WEST SUSSEX COUNTY COUNCIL CONSULTATION

TO:	Arun District Council FAO: Michael Eastham
FROM:	Stephen Gee WSCC - Highways Authority
DATE:	16 November 2020
LOCATION:	Land west of Tye Lane Walberton
SUBJECT:	WA/68/20/OUT Outline application with all matters reserved, other than means of access, for the construction of up to 155 No. dwellings (30% affordable homes) & amendment to boundary of garden land to serve adjoining property. This application affects the character & appearance of the Walberton Village Conservation Area, may affect the setting of listed buildings & is a Departure from the Development Plan.
DATE OF SITE VISIT:	
RECOMMENDATION:	More Information
S106 CONTRIBUTION TOTAL:	n/a

The application is for upto 155 dwellings with all matters reserved except for access at Land West of Tye Lane, Walberton.

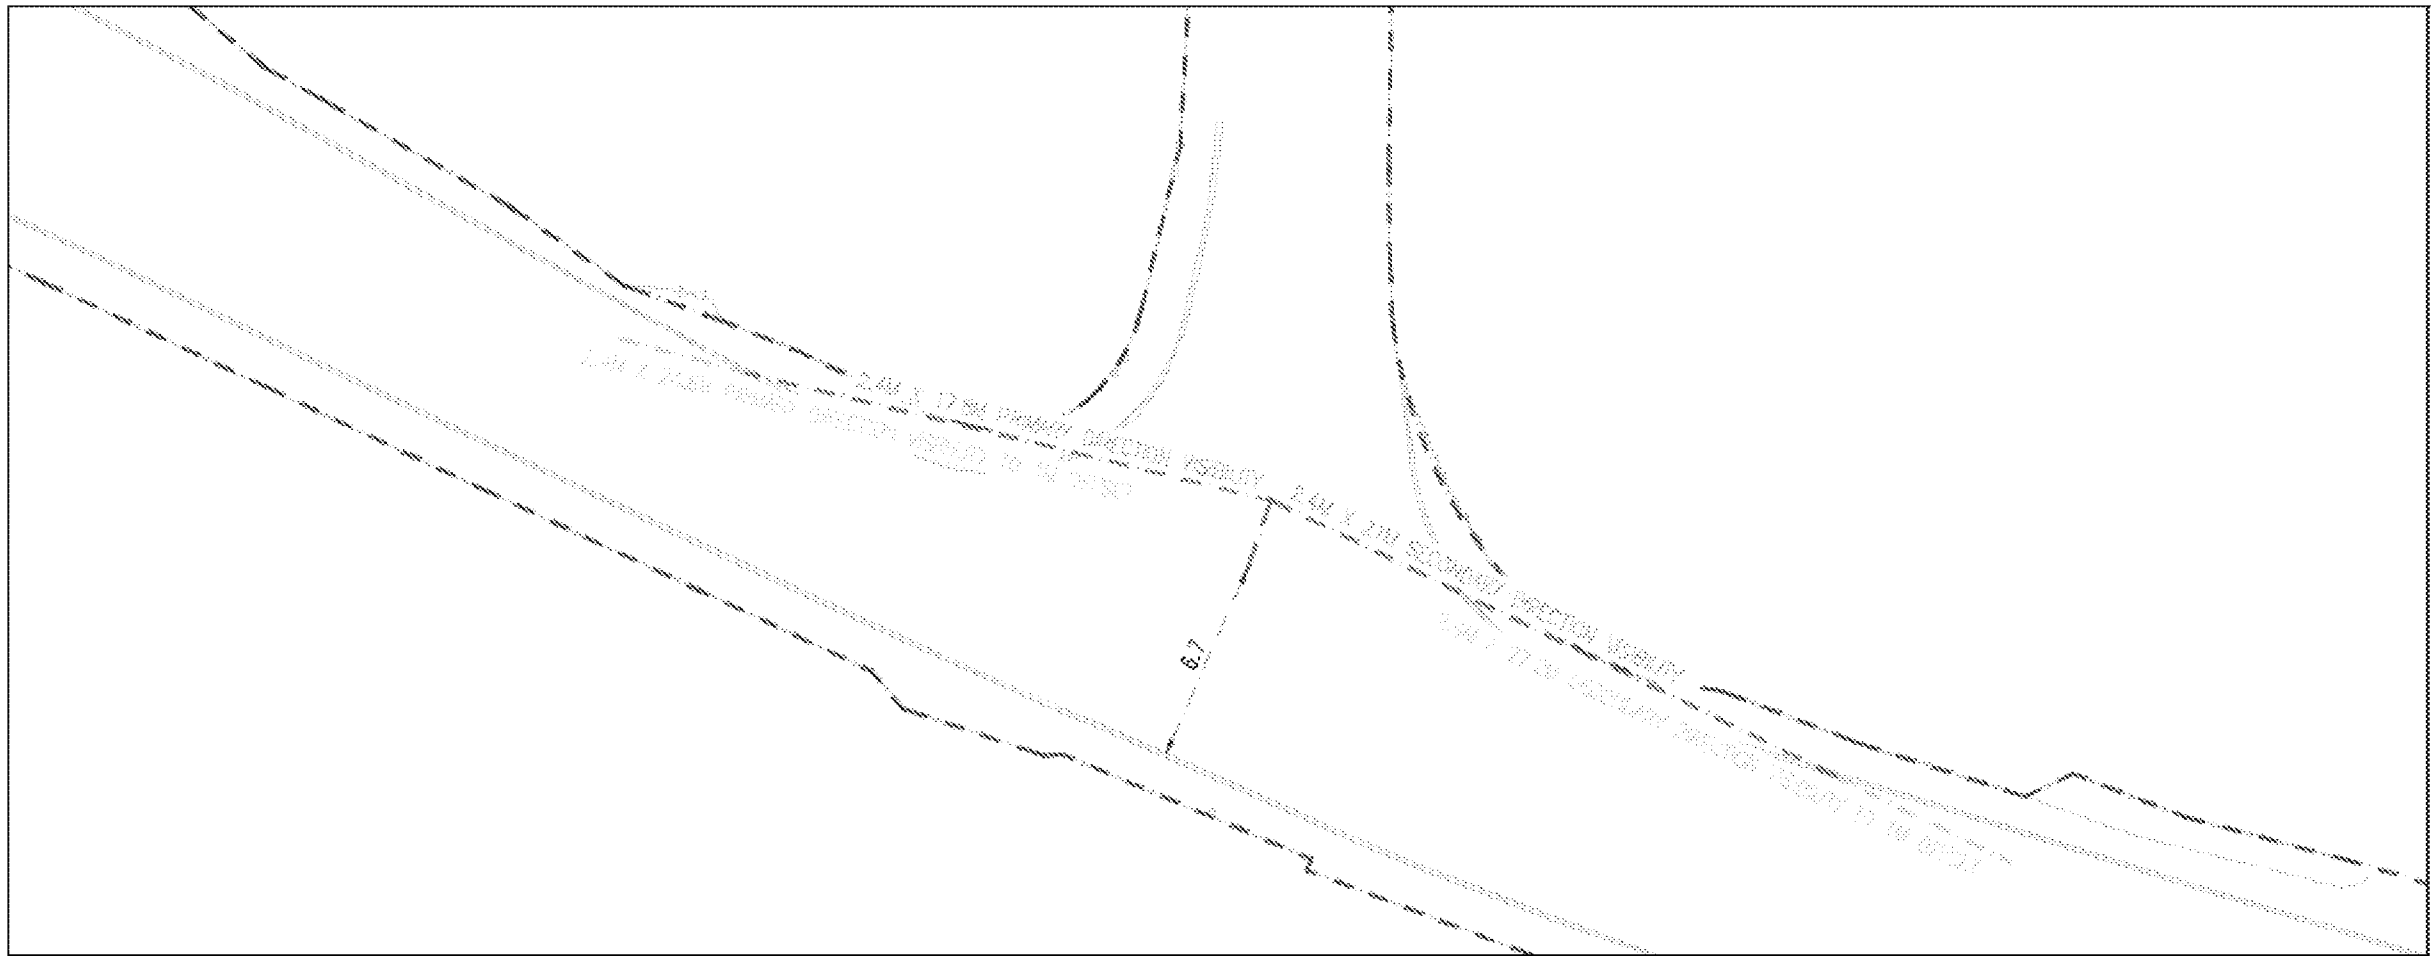
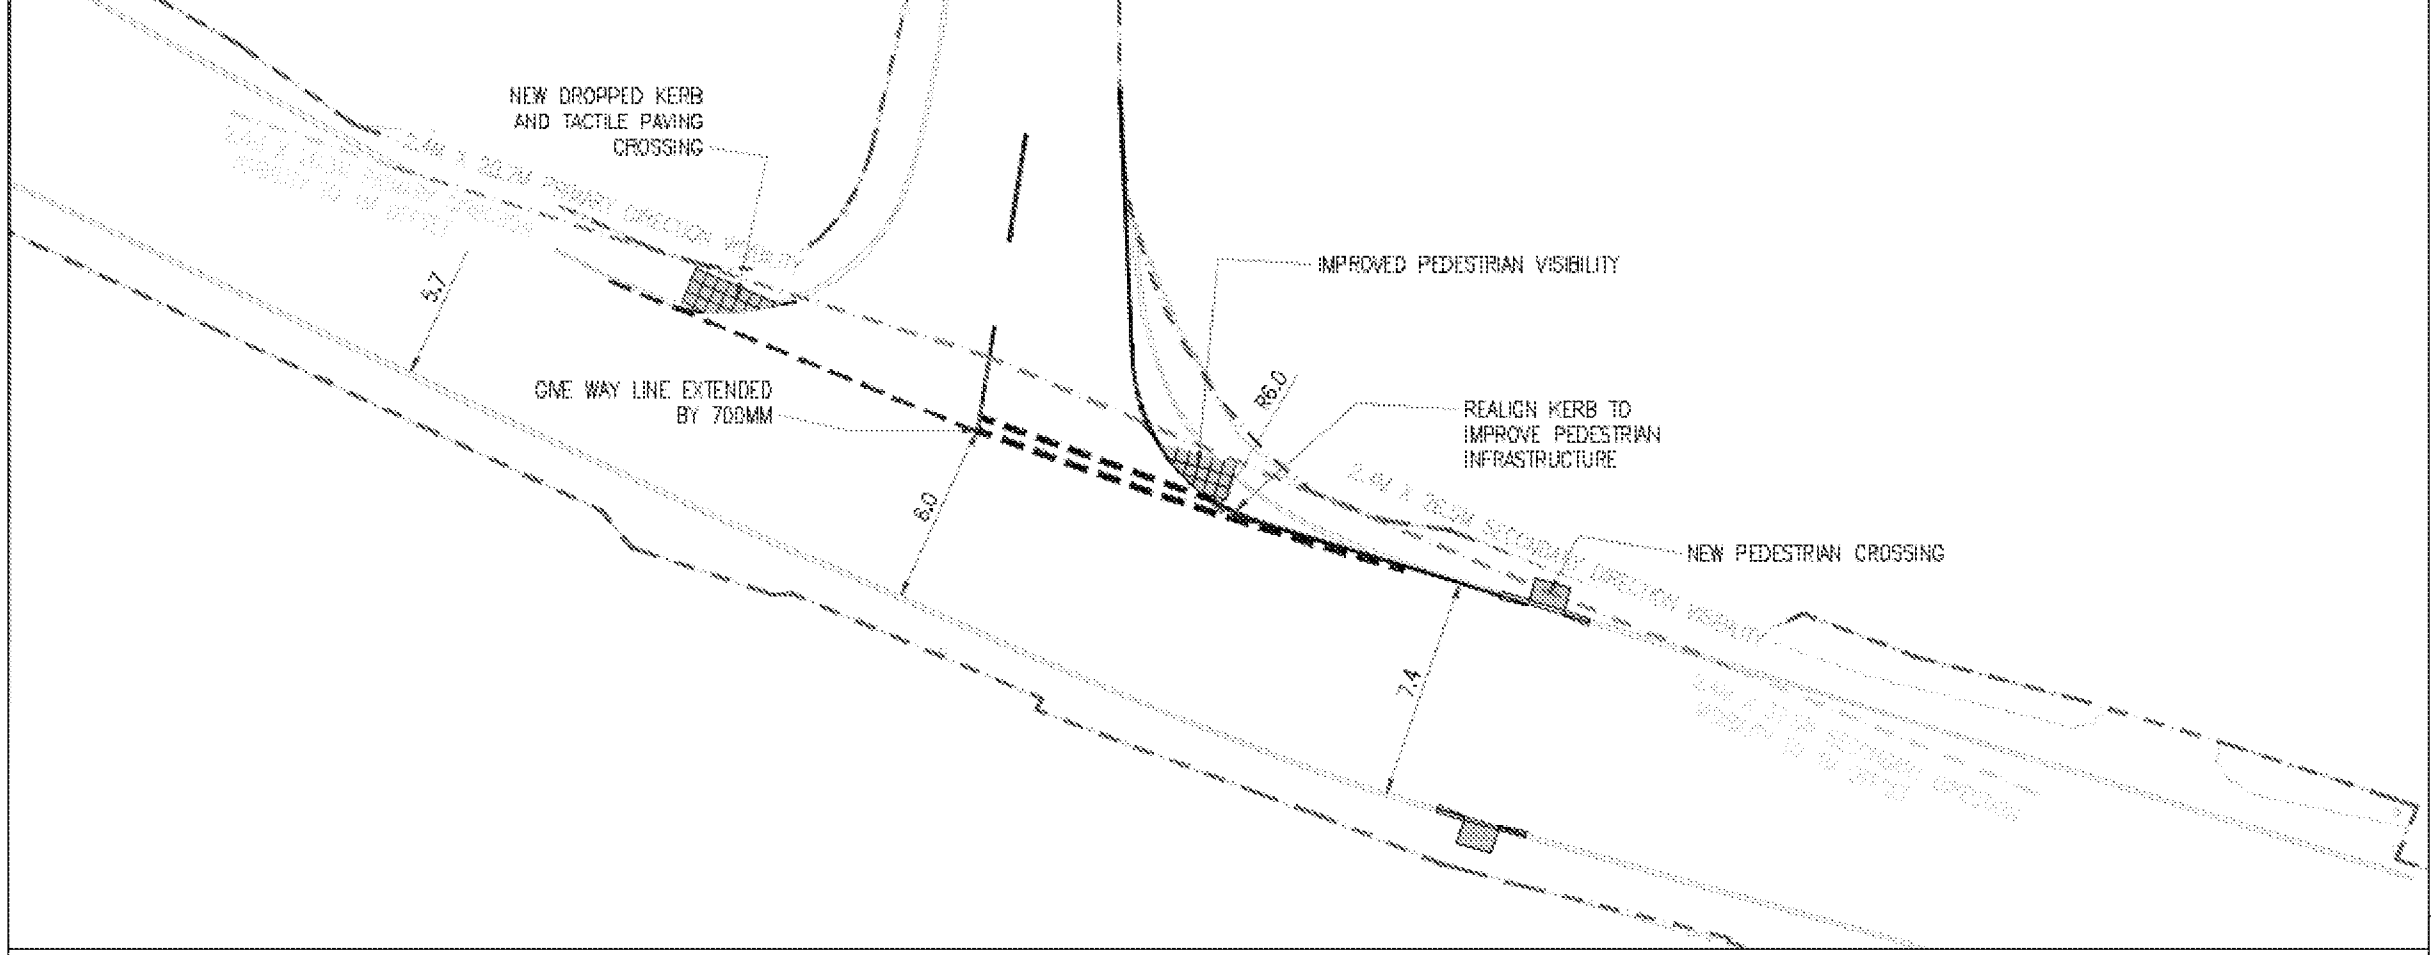
A stage 1 RSA has been undertaken and modifications to the give way line proposed.
